EL PASO COUNTY GRADING AND EROSION CONTROL PLAN CHECKLIST

EPC Project Number:

LATIGO TRAILS - FILING NO. 9	BY	DATE				
	No.	REVISION				
GRADING AND EROSION CONTROL PLAN	H-SCALE	1"=50'	N/A			
	V-SCALE					
SHEET 8 OF 14	DATE	09/10/21	DESIGNED BY	APL	DRAWN BY	RWK
			CHECKED BY			
JOB NO.	25175.01

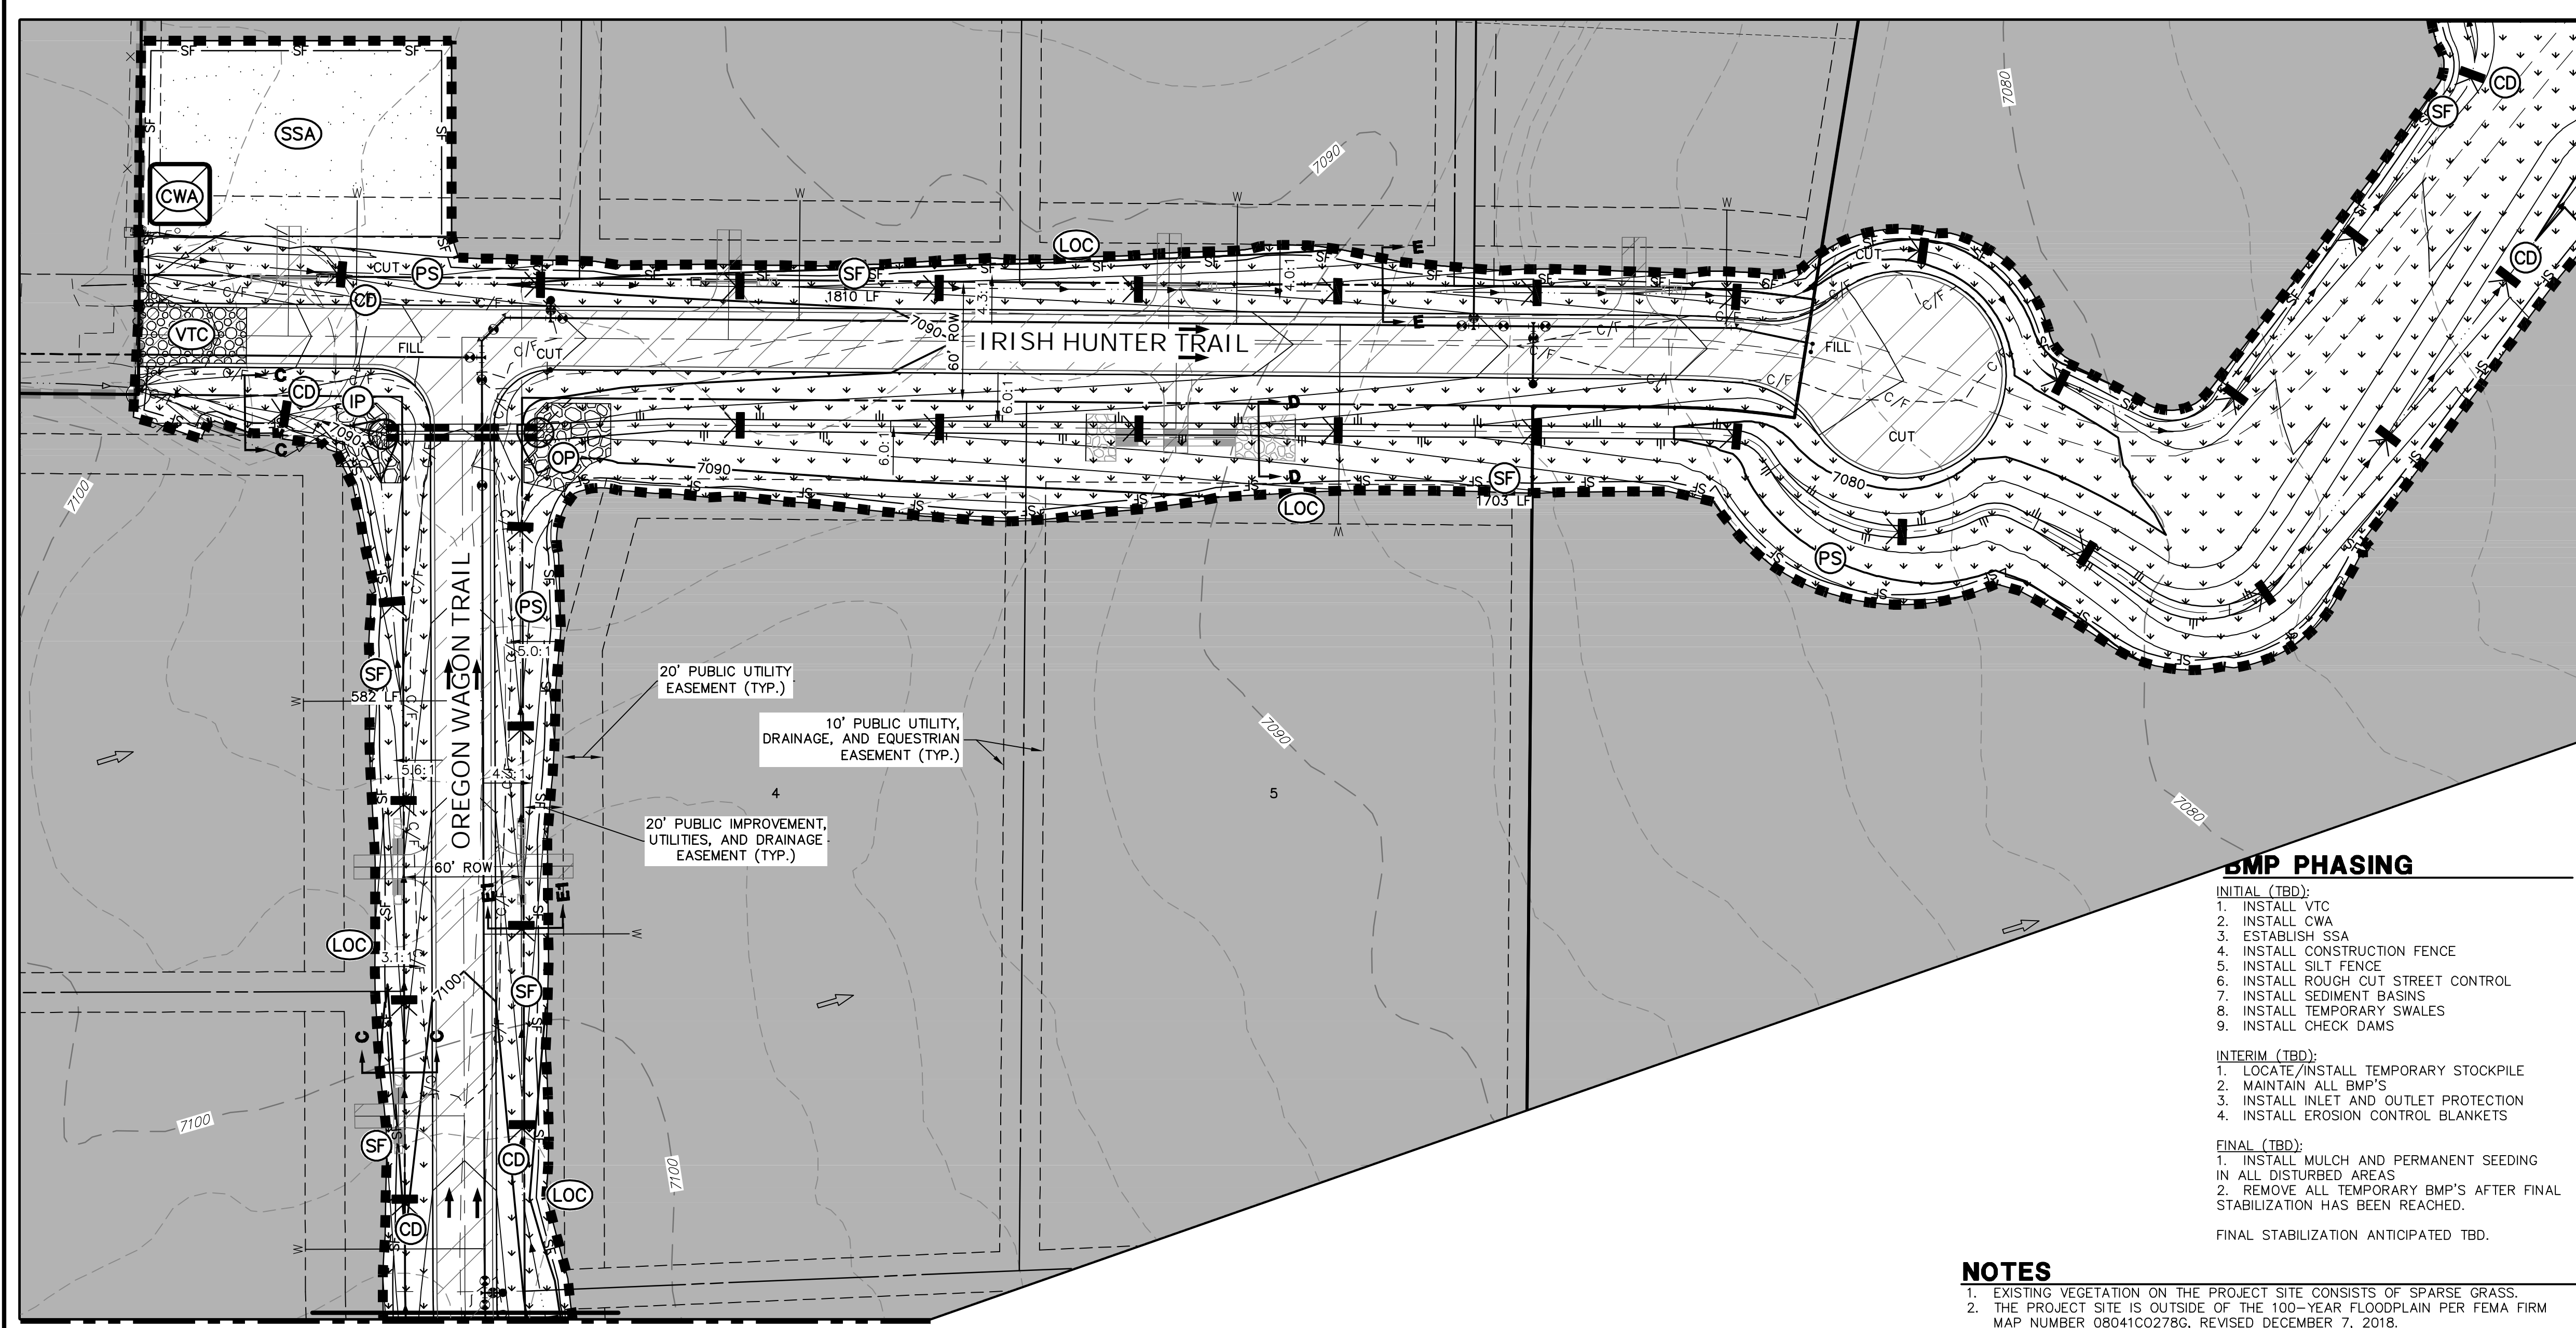
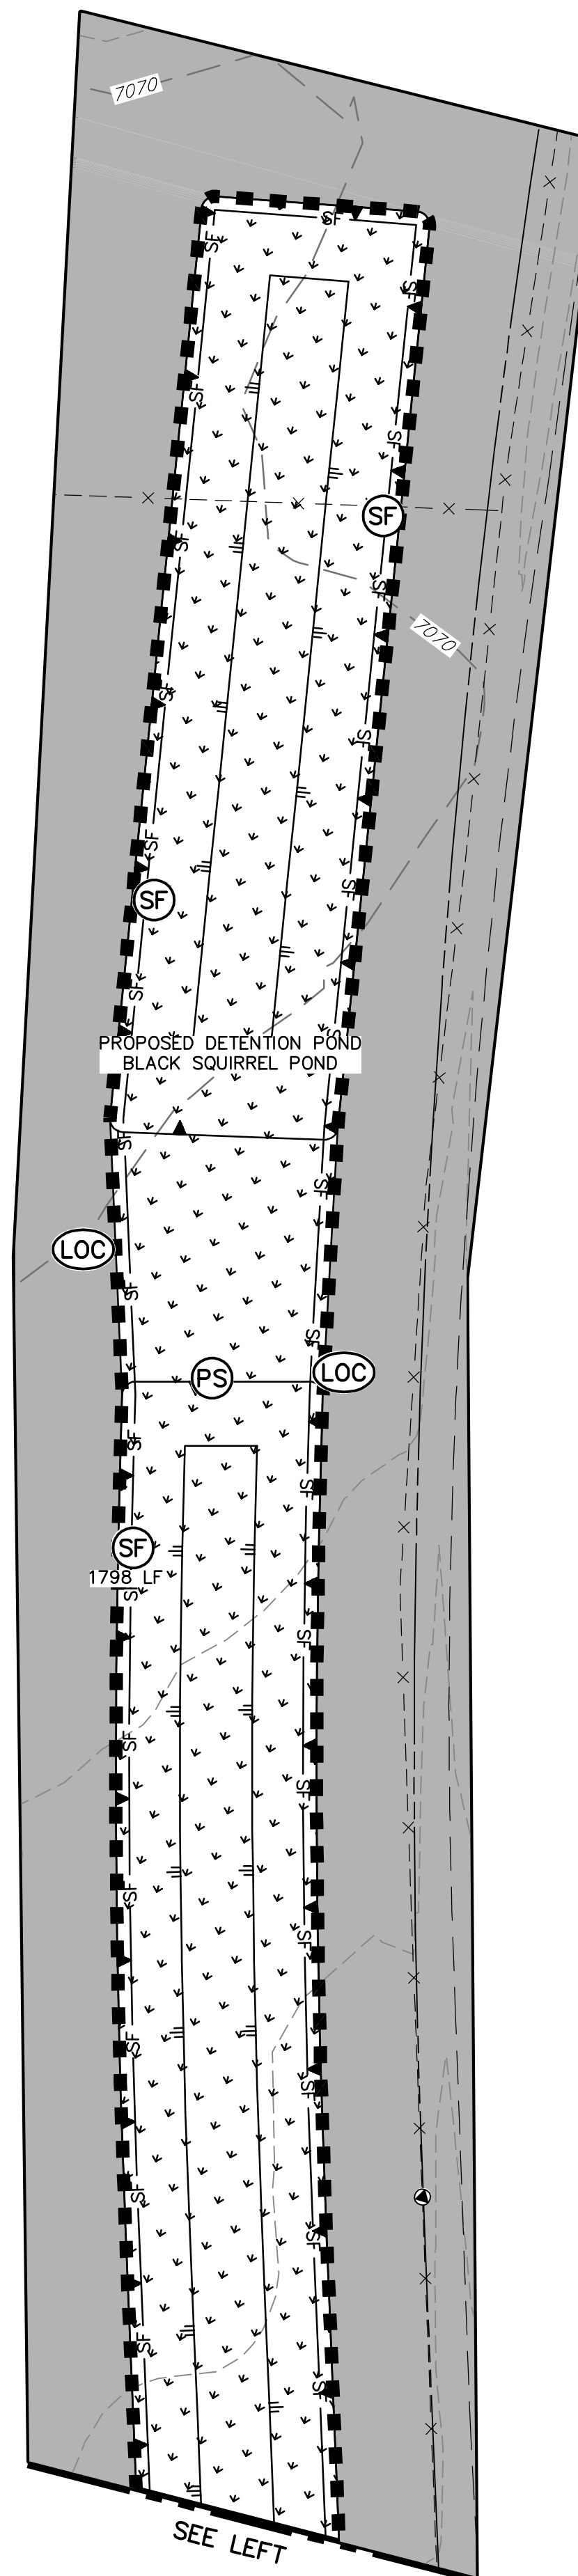
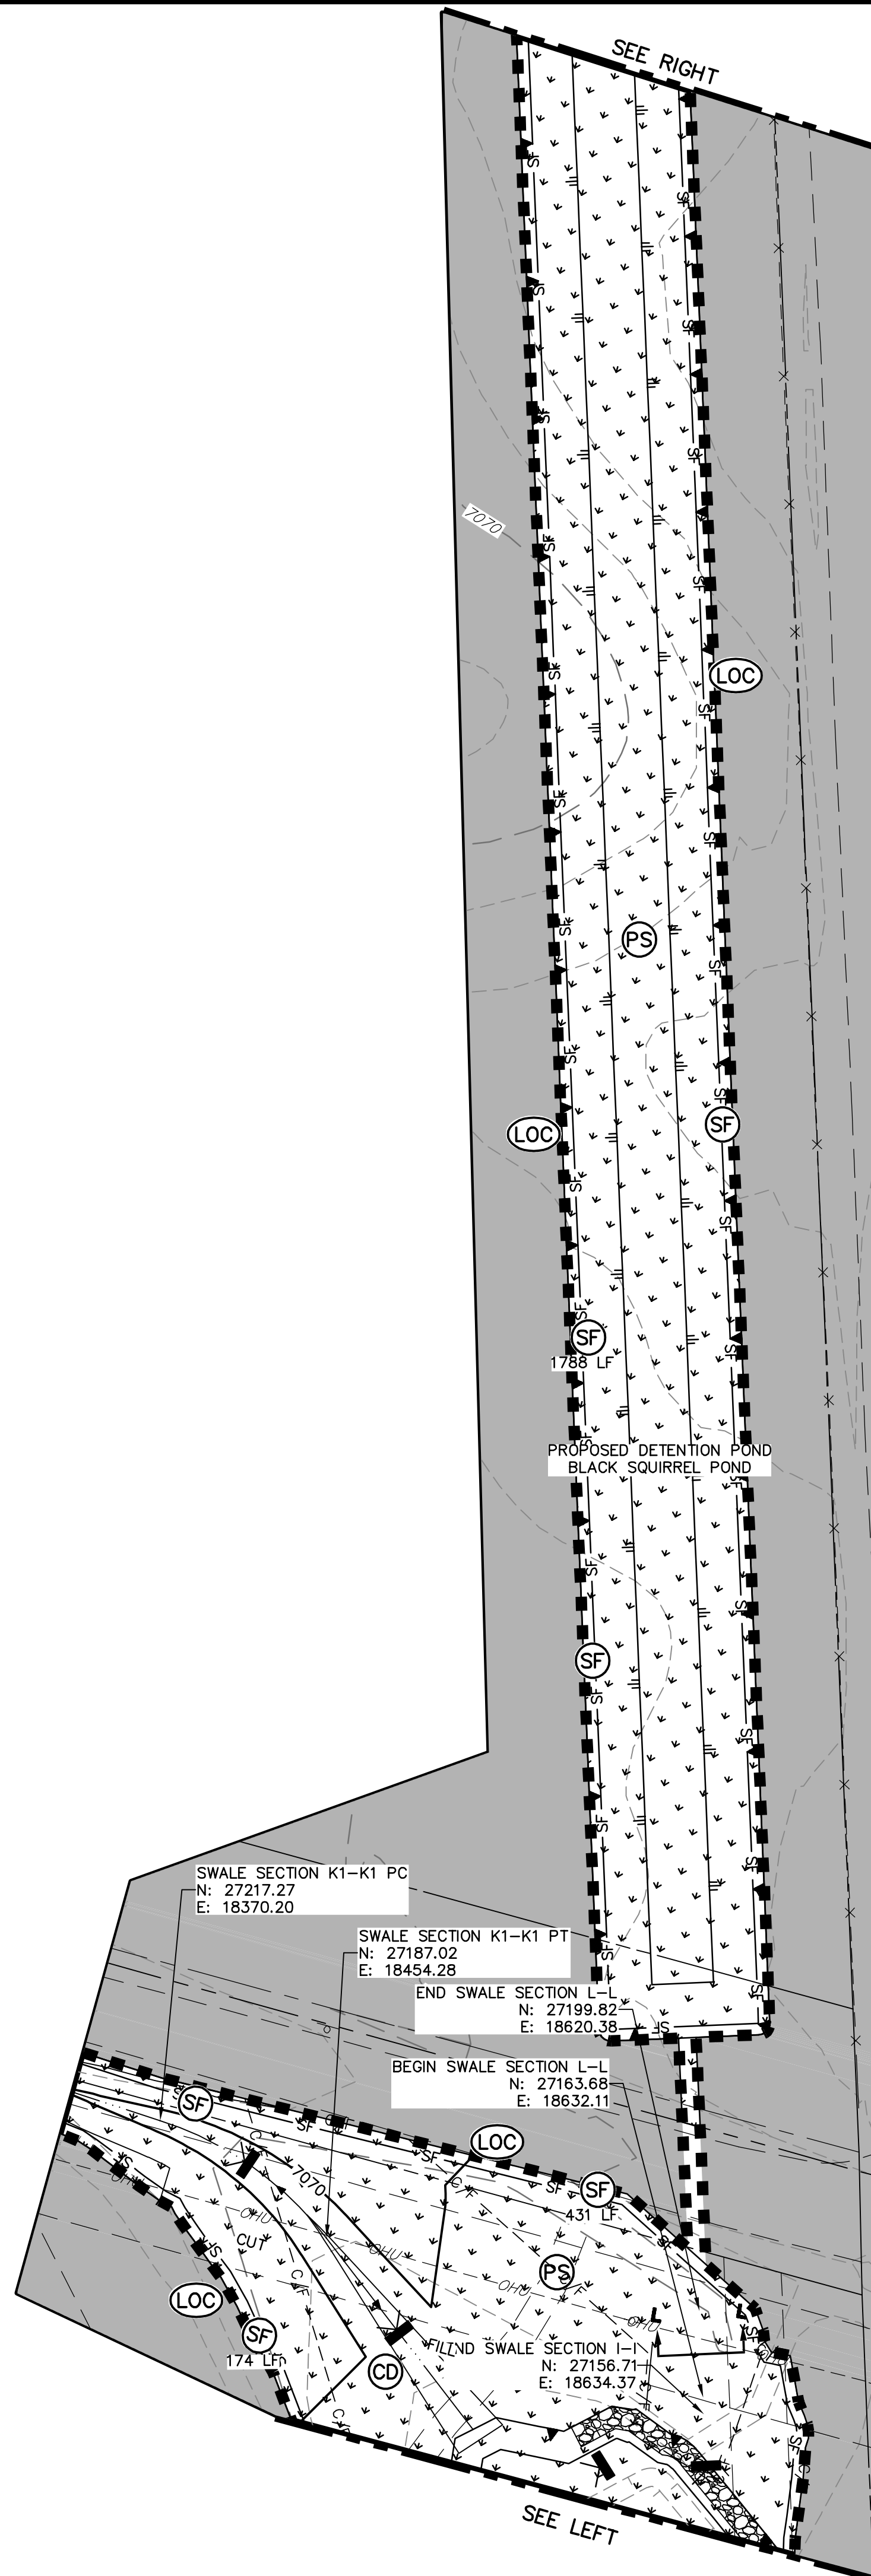
Please review outfall of all ditches and swales to make sure that all tributary areas >1ac are being conveyed to a TSP.
